**WELWYN HATFIELD BOROUGH COUNCIL – DEVELOPMENT MANAGEMENT**  
**DELEGATED REPORT**

<b>APPLICATION No:</b>	<b>S6/2012/1879/FP</b>
<b>APPLICATION Site:</b>	<b>24 Church Street, Hatfield</b>

The proposal seeks planning permission for the replacement of the existing front elevation windows on a 'like for like' basis apart from the two basement/cellar windows which will remain as they are. The changes relates to introducing double glazing where single glazed windows currently exist.

24 CHURCH ST
HATFIELD. HERTS.
AL9 5AW
CHARLOTTE
PRESCOTT.

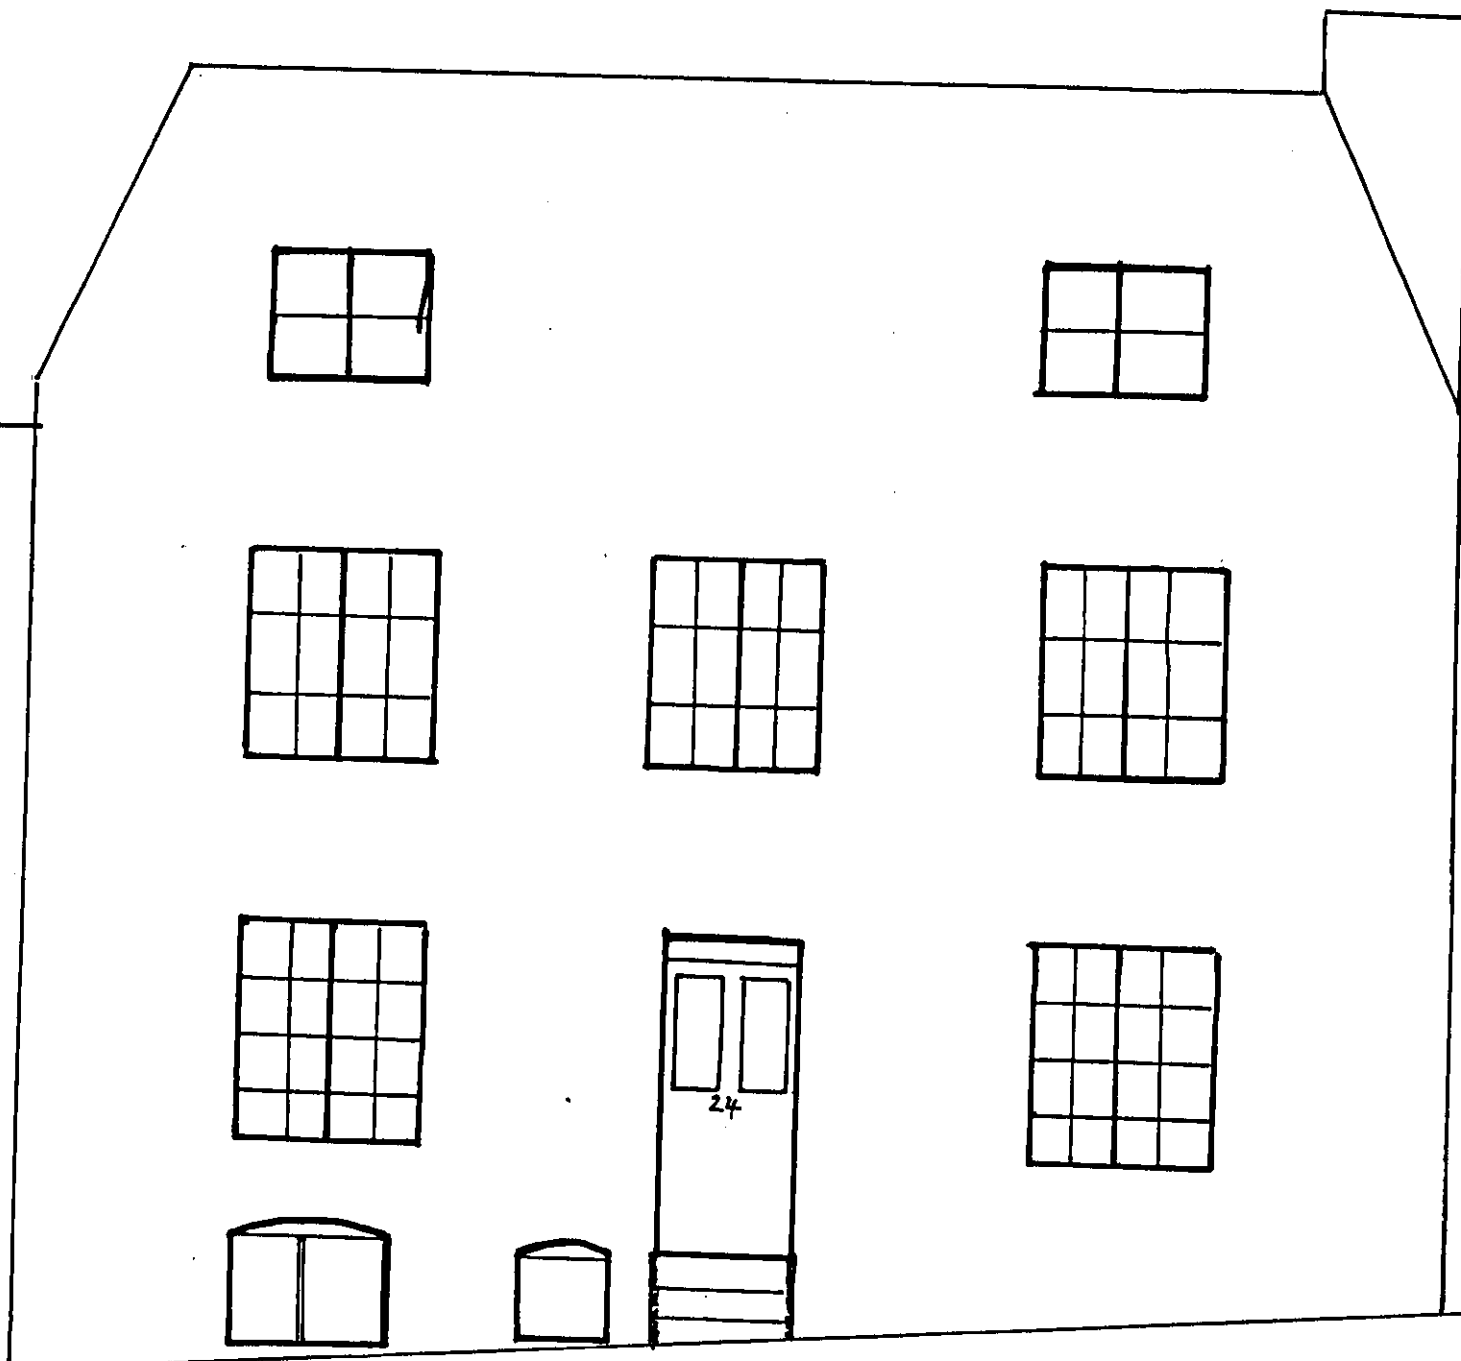
The proposed replacement windows are on a like for like basis in terms of the design and visual appearance. The Georgian glazing bars are to remain as part of the proposal. The introduction of double glazing element will be minimal in terms of the proposed spacing between the two glazing panels and therefore the introduction of double glazing would remain sympathetic to the character and appearance of the original building and the existing streetscene when the development has been completed.

Subject to compliance of condition which requires the replacement windows to be painted in white gloss, the proposed alterations would sustain the character and appearance of the historic environment, the application site and the Old Hatfield Conservation Area in accordance with the National Planning Policy Framework and Policies, GBSP2, D1 and D2 of the Welwyn Hatfield District Plan 2005.

1. C.2.1 Time limit for commencement of development
2. C.13.1 Development in accordance with approved plans/details: Site Location Plan (1:1250) & Drawing No.1 & Proposed Front Elevation received and dated 18 October 2012
3. The replacement windows hereby approved shall be painted in white gloss unless otherwise approved in writing by the Local Planning Authority
